4th October 2013

Planning application, Council Office Extension ref. N6/2013/1938/MA

Title Proposed Materials

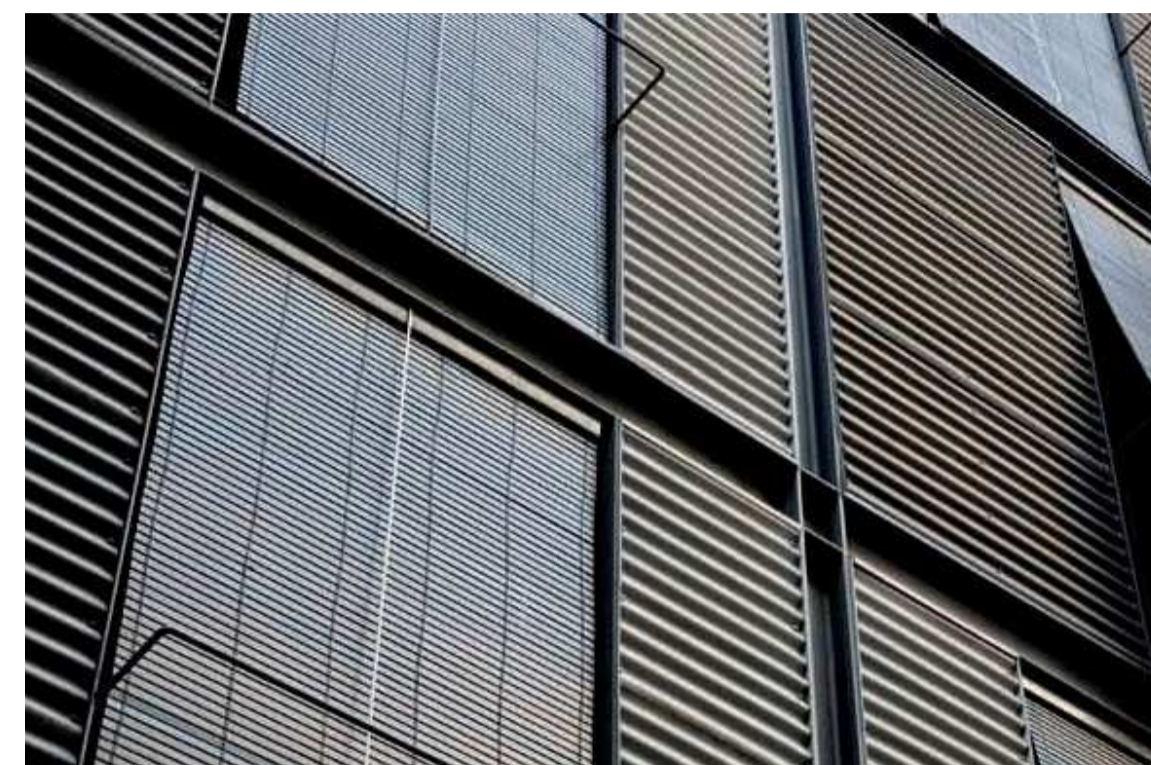
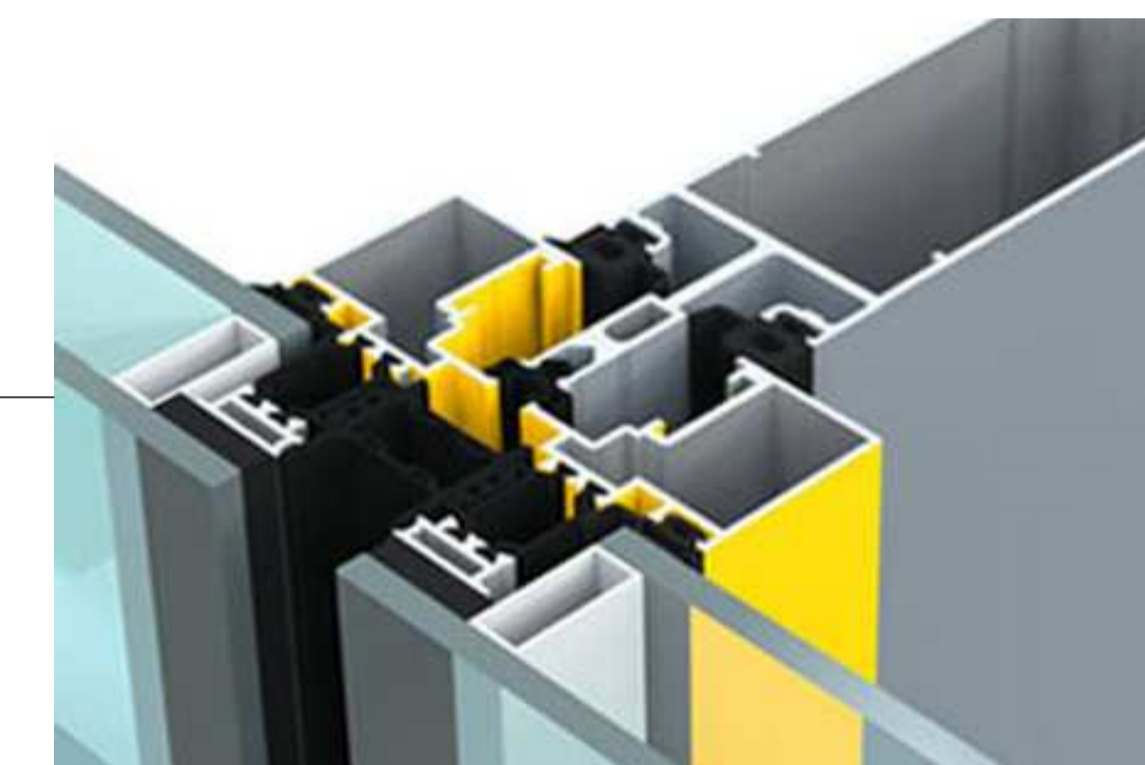
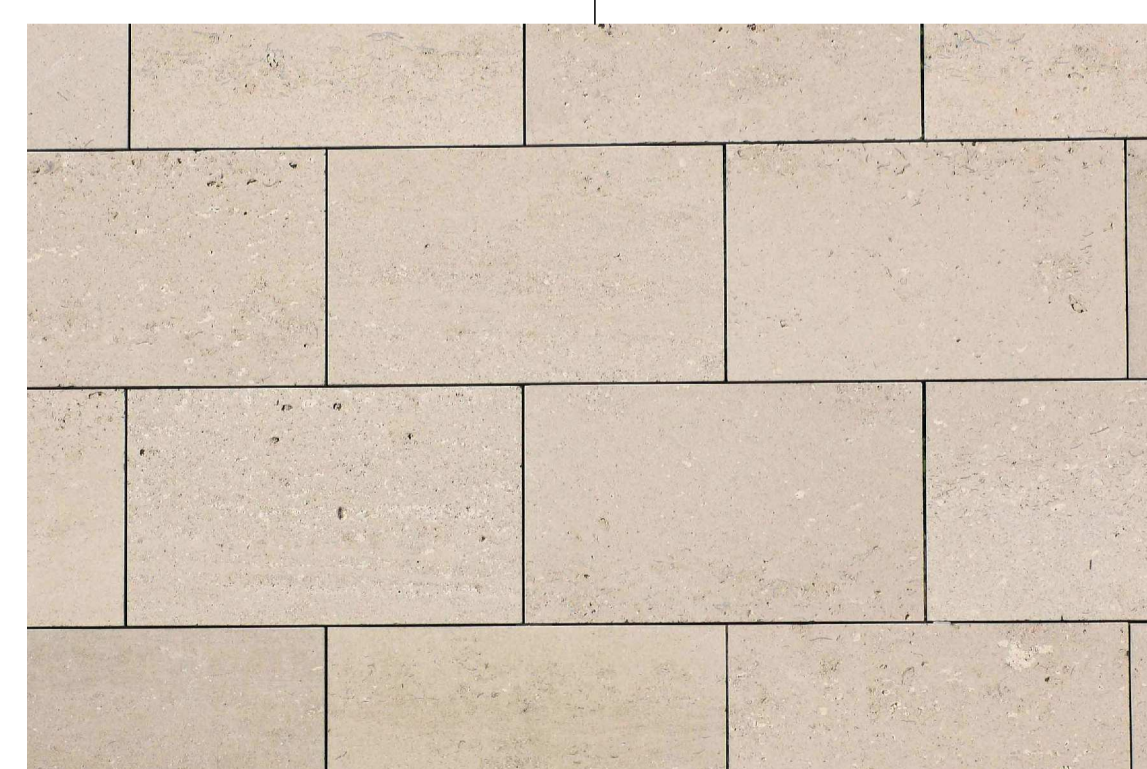
This extension will be in the conservation area and will be integral to a building which has an award winning design. The application proposes to build the new extension with brickwork that contrasts with the red brick of the existing buildings. The rationale is that the current bricks cannot be matched so a contrast is the best solution. This is complete rubbish.

We are aware that the council requires that extensions proposed in the conservation area of our Garden City *must* be sympathetic and subservient to the original building and to surrounding buildings. The constant stream of extensions in the conservation area are all in matching brick. This is just one example of how the consultants are trying to force their 'artistic' views on to the Council in defiance of local planning and design requirements. It would surely be unthinkable for the Council to approve an application that drives a coach and horses through its own planning requirements. If this extension were proposed by a Garden City resident, it would be rejected immediately.
